**APPLICATION NO:** 2020/0613

**DESCRIPTION:** Proposed 22.50 m high telecommunications lattice tower and associated equipment (prior approval).

**LOCATION:** Land off Wood Street, Wombwell, Barnsley, S73 0LH

We hereby advise you that prior approval is required, and it is the decision of the Local Planning Authority to **refuse** the submitted details of the scheme for the following reason(s).

Title: 265 MAX CONFIGURATION ELEVATION

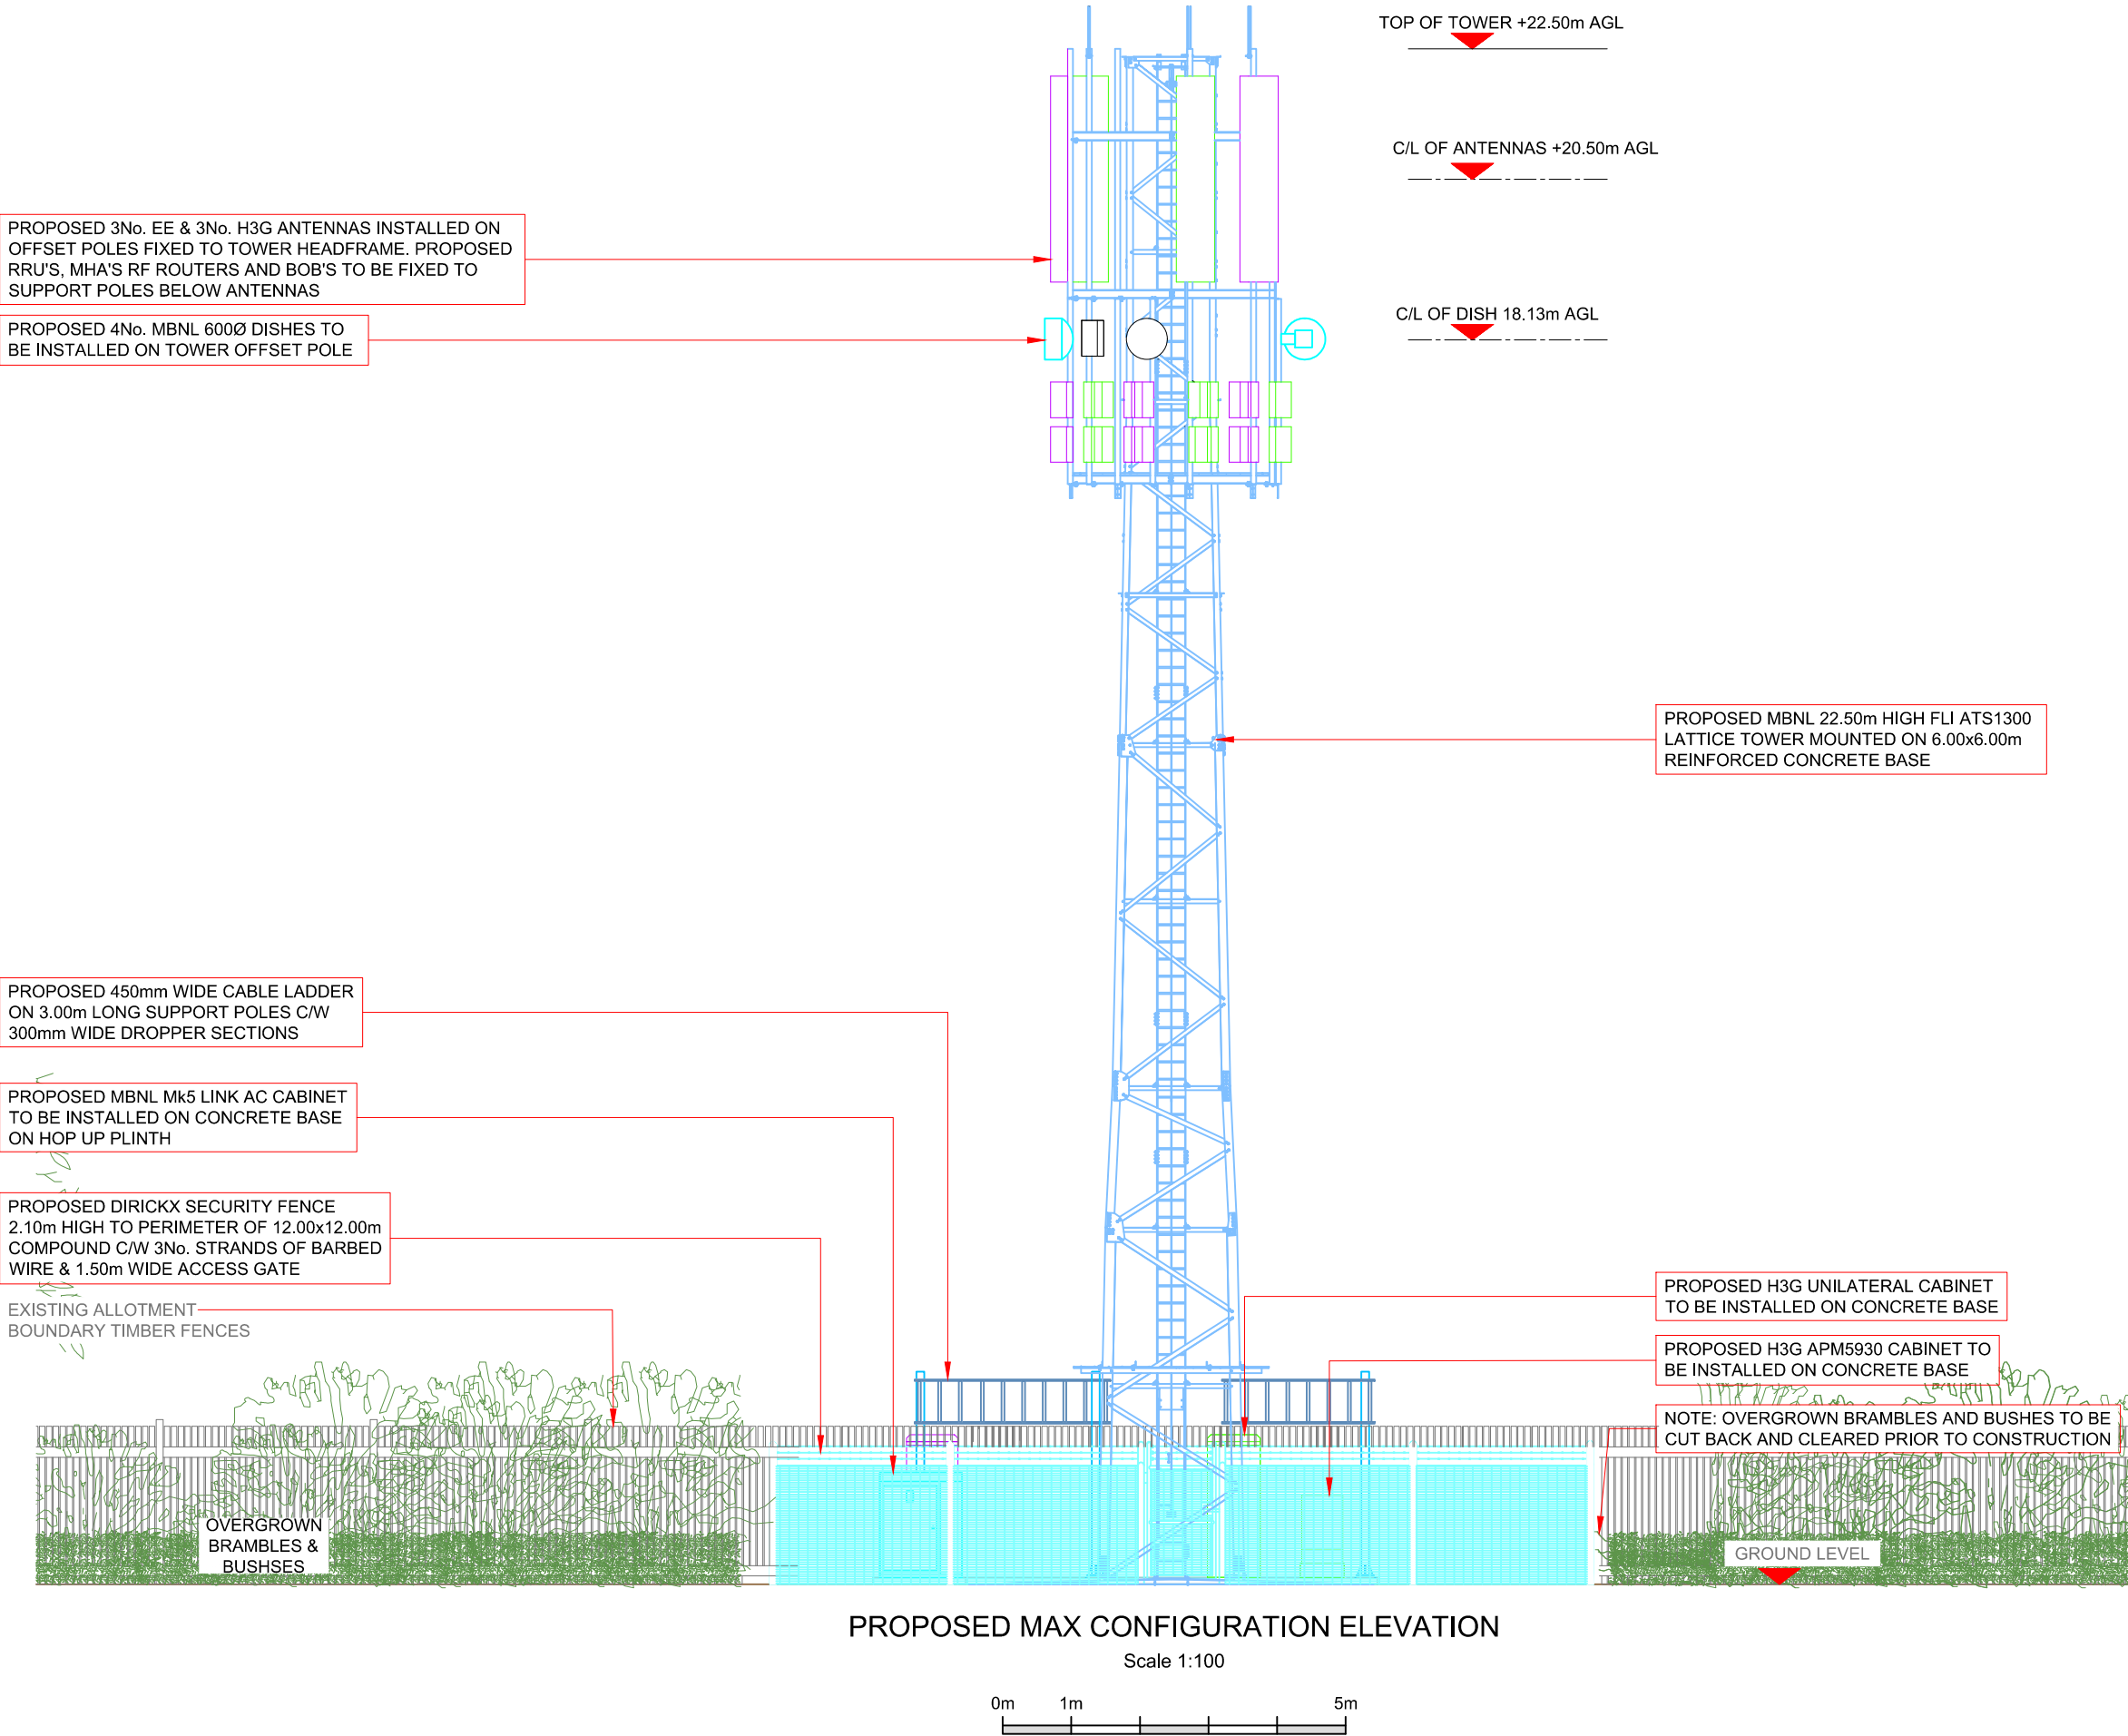
- 1 In the opinion of the Local Planning Authority the development would materially harm the visual amenities of the locality by virtue of its excessive height and the bulk of the antenna head which would make it an overly dominant feature in close proximity to existing residential dwellings on Hough Lane which in turn would have a detrimental impact on their outlook. The proposal is therefore contrary to Local Plan policies D1 High Quality Design and Place Making and GD1 'General Development'. Furthermore, insufficient information has been submitted regarding the design, safety and security of the proposed fencing - despite this information being requested by the Local Planning Authority.
